Essex County Fire and Rescue Service

Initial Response to Longfield Solar Farm

This document outlines Essex Fire and Rescue Service's initial response to the consultation for the proposed development.

Primary Access Road Cross Section

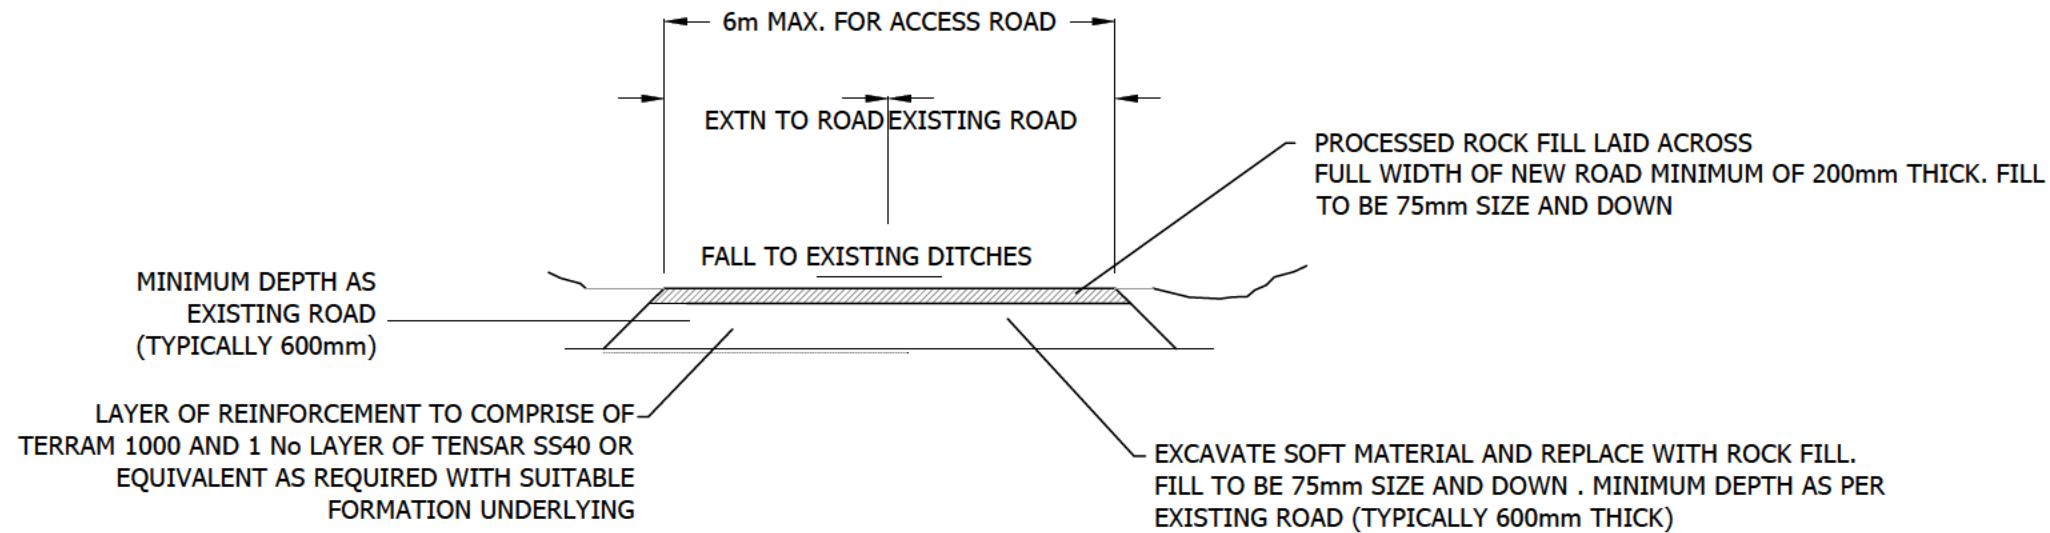
- Provision of suitably spaced hydrants and where necessary an Emergency Water Supply (EWS).
- Consideration for road widths to be accessible whilst not impeding emergency service vehicle response through safe access routes for fire appliances including room to manoeuvre (such as turning circles).

- A secondary access point for emergency service vehicles should the primary access route be unsuitable due to prevailing wind conditions.
- Adherence to the requirements of the Fire Safety Order and relevant building regulations, especially approved document B.
